Department of
Infrastructure, Planning and Natural Resources

Planning Assessment Report

Development Application DA 492-11-2003

The application seeks consent for the erection of a four (4) storey building with four (4) tourist units, ground floor retail space, parking, gymnasium and cinema.

DRAWING TITLES
 GROUND FLOOR PLAN

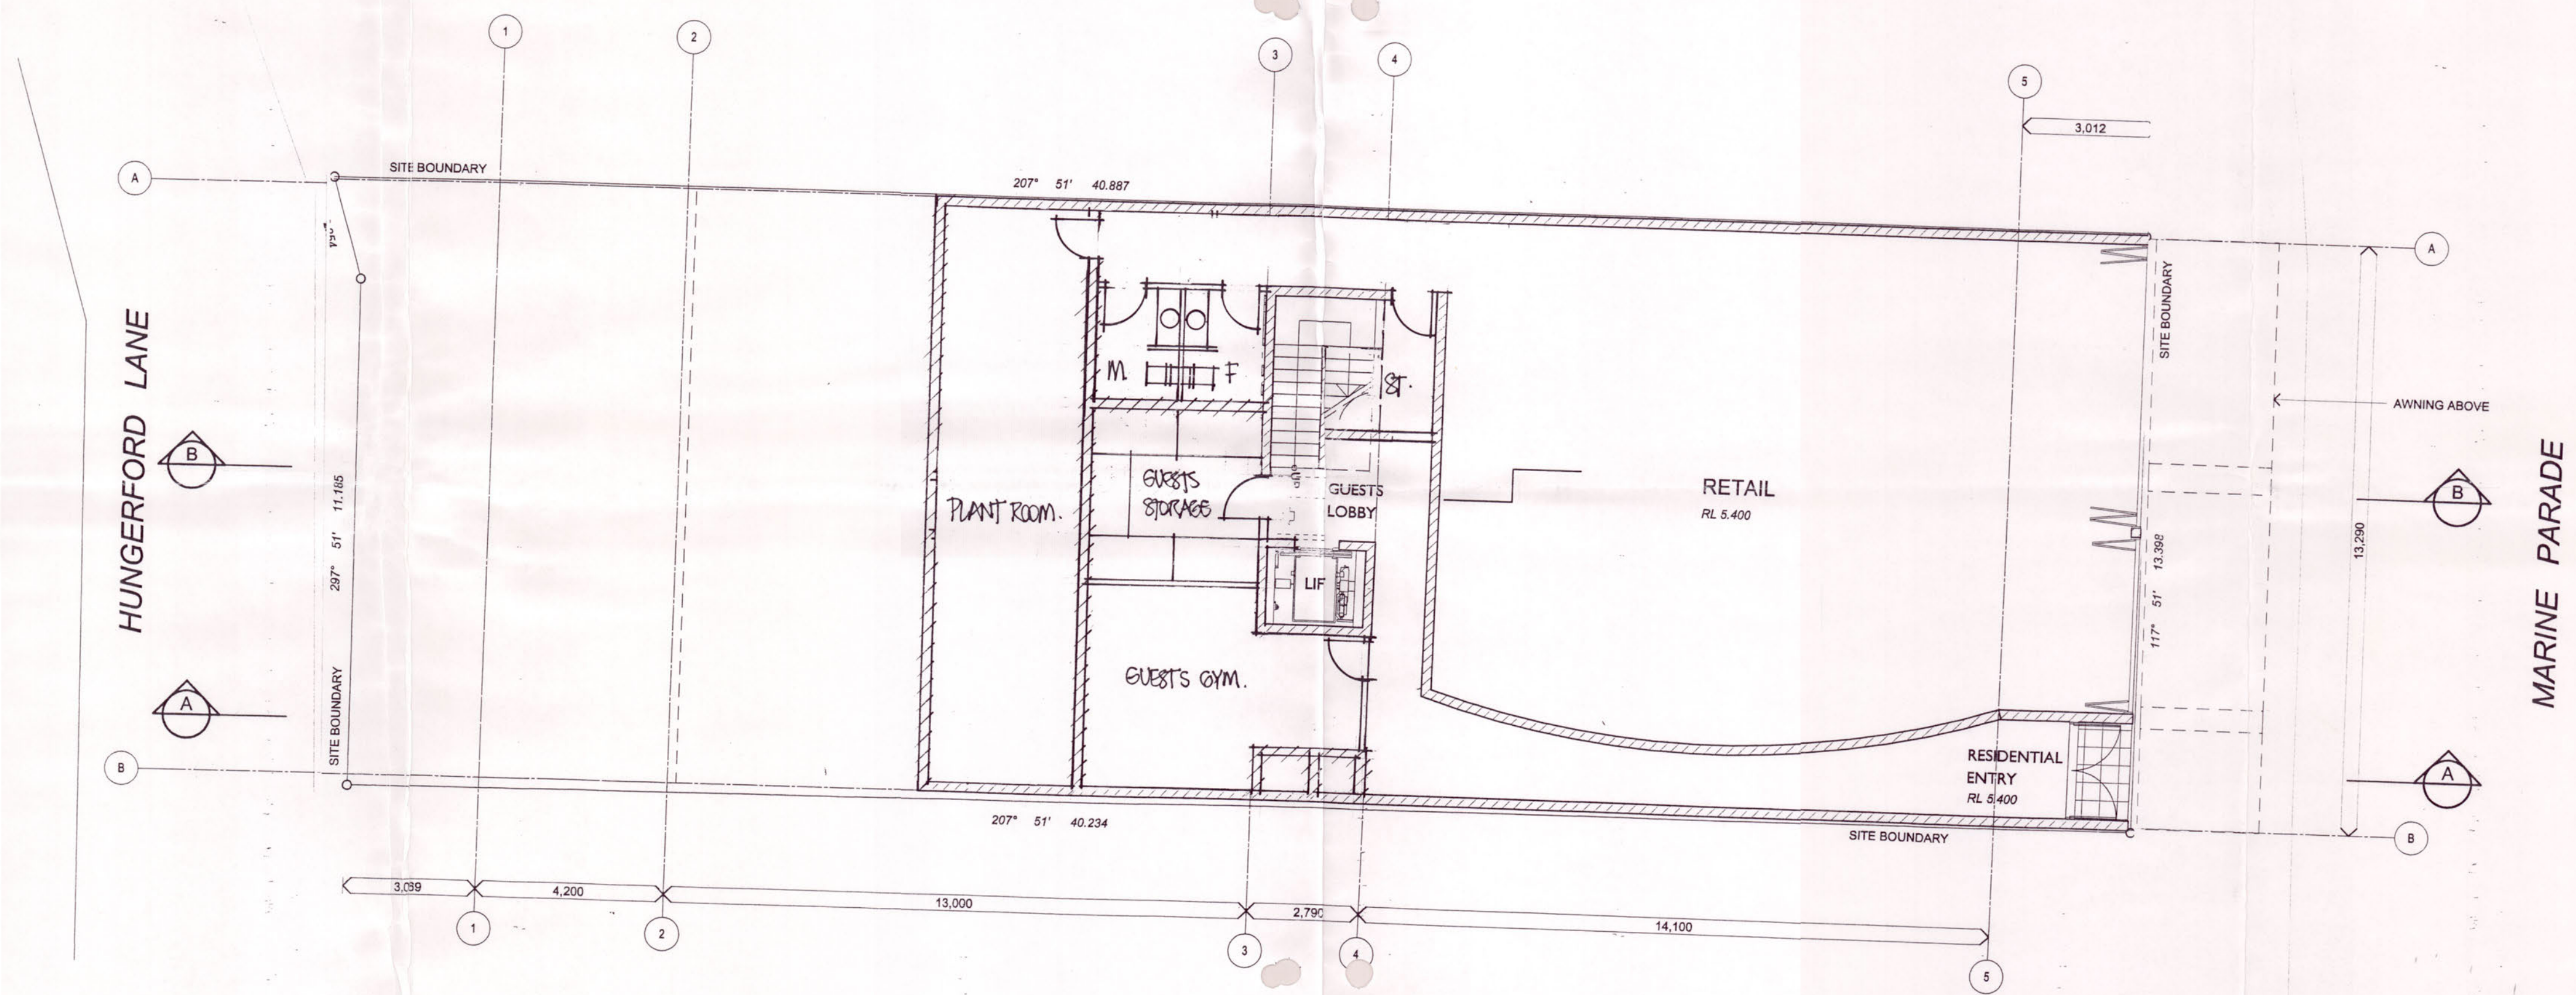
Issue: Reduction in car parking space

Consideration: The proposed development shares driveway access with the adjoining property and as such 2 car parking spaces for the adjoining site are located on this site(part of a condition of the DA for the adjoining property). The total number of car parking spaces required for guests and retail staff and the adjoining property is 15. The site contains only 8 car spaces. The breakdown of car spaces is; 2 for the adjoining property, and 6 car parking spaces for this site. Included in this is 1 disabled space. This leaves a deficit of 7 car parking spaces.

Resolution: Council agreed to the reduction in car parking spaces, however, conditioned Section 94 contributions for each deficit car parking space.

DRAWING TITLES
THIRD FLOOR PLAN

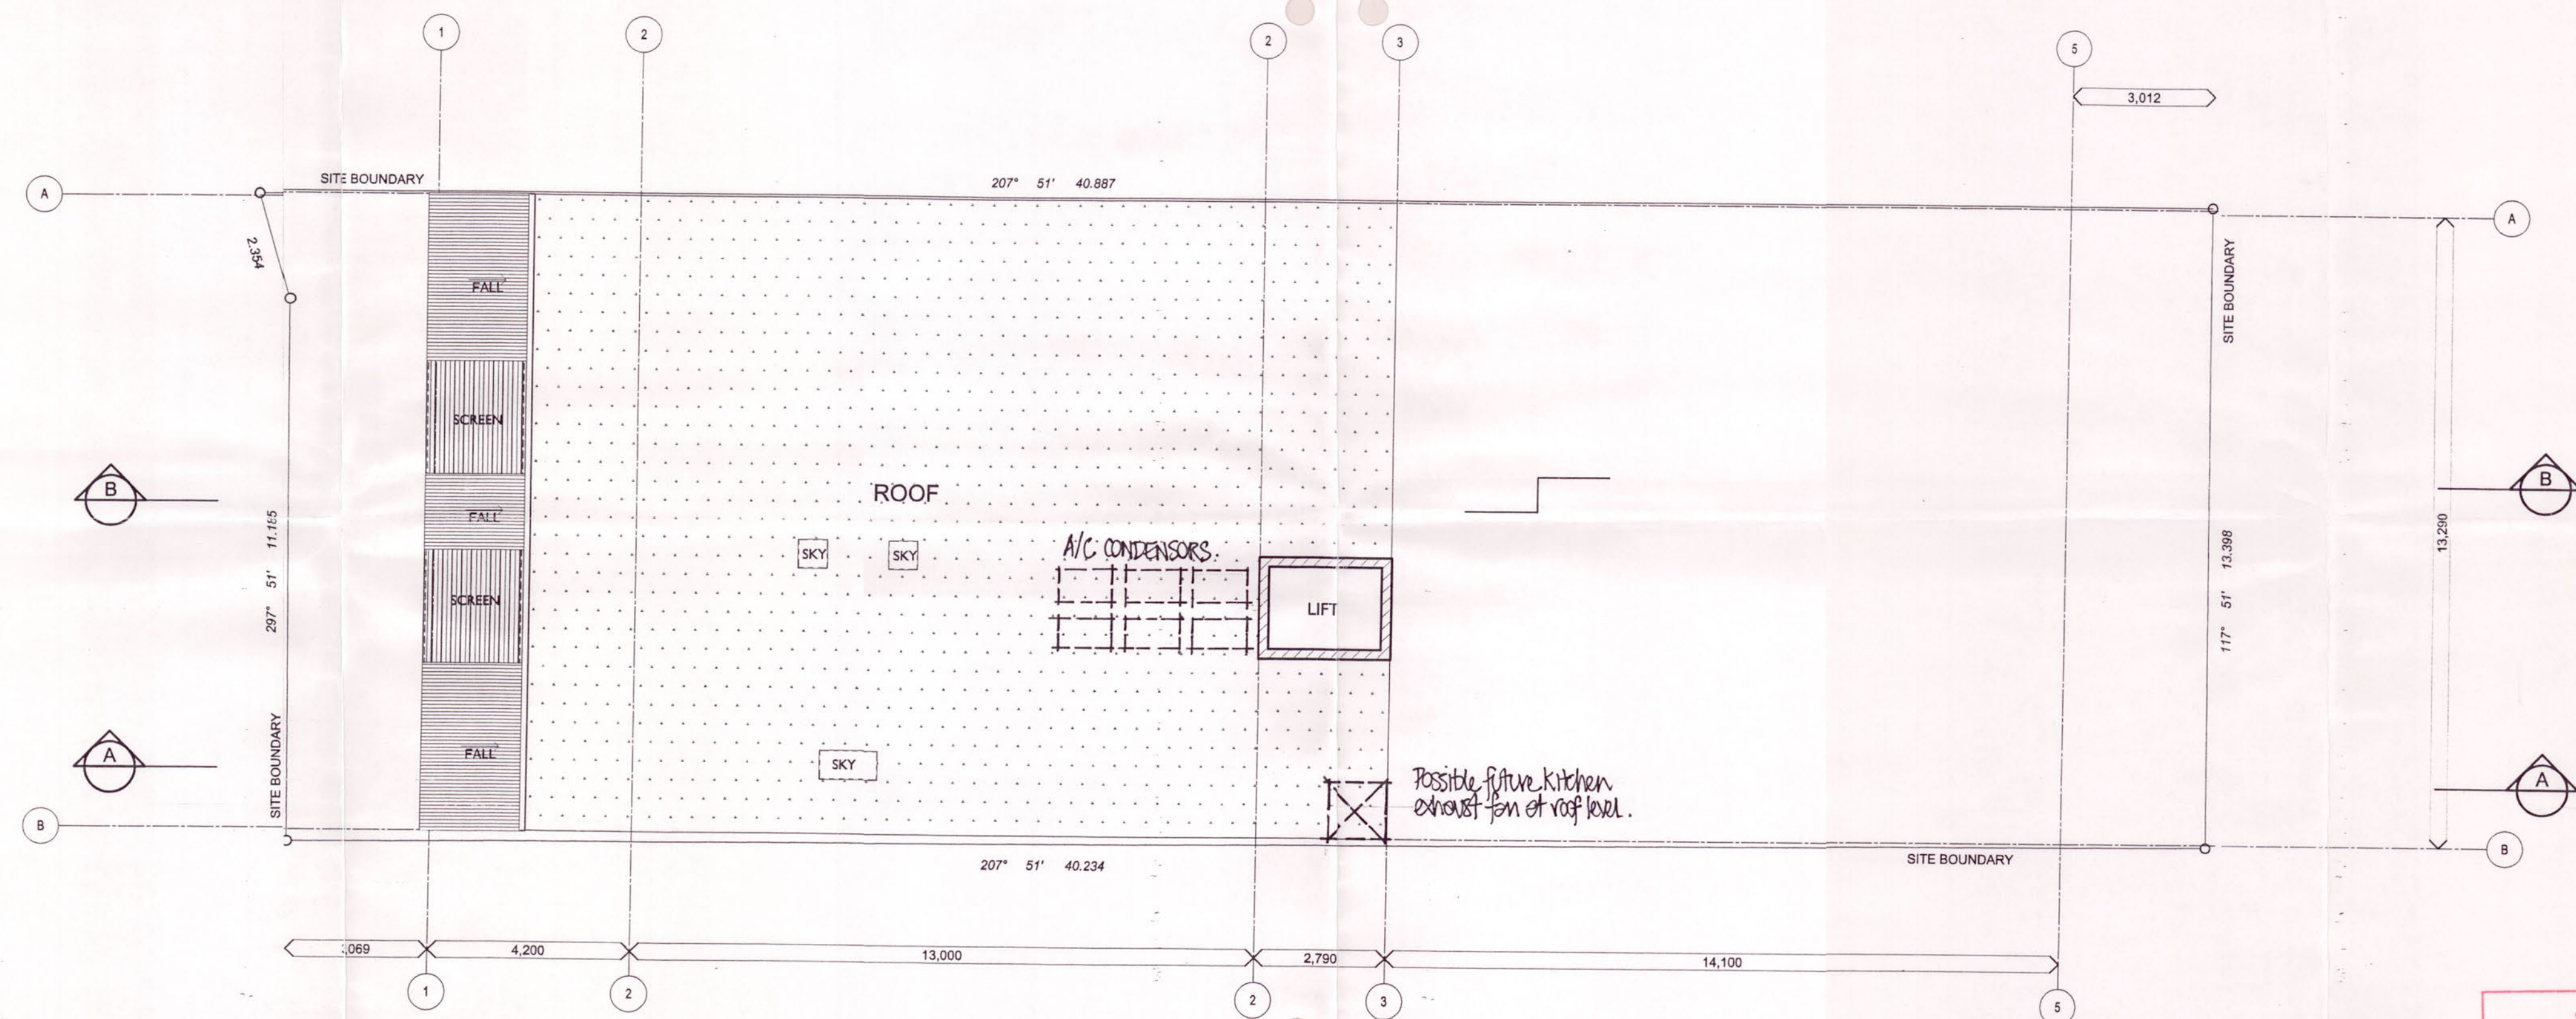
Consideration: A small plunge pool is to be located at the front terrace of the 3rd storey unit not the roof top. It will not be visible from adjoining properties as the pool is located on the terrace fronting onto Marine Parade with the 3rd floor unit acting as a barrier to potential noise from the terrace area.

DRAWING TITLES
ROOF PLAN

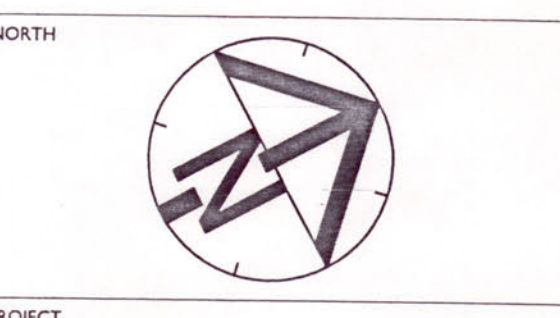
Issue: Pool and flue/exhaust on the rooftop

The issue of flues/exhaust on the roof has the potential to reduce views and be unsightly. However, Council requires flues to be roof vented.

Resolution: A condition has been imposed to control outlets on the roof top with adequate screening to ensure no further loss of view in the future.
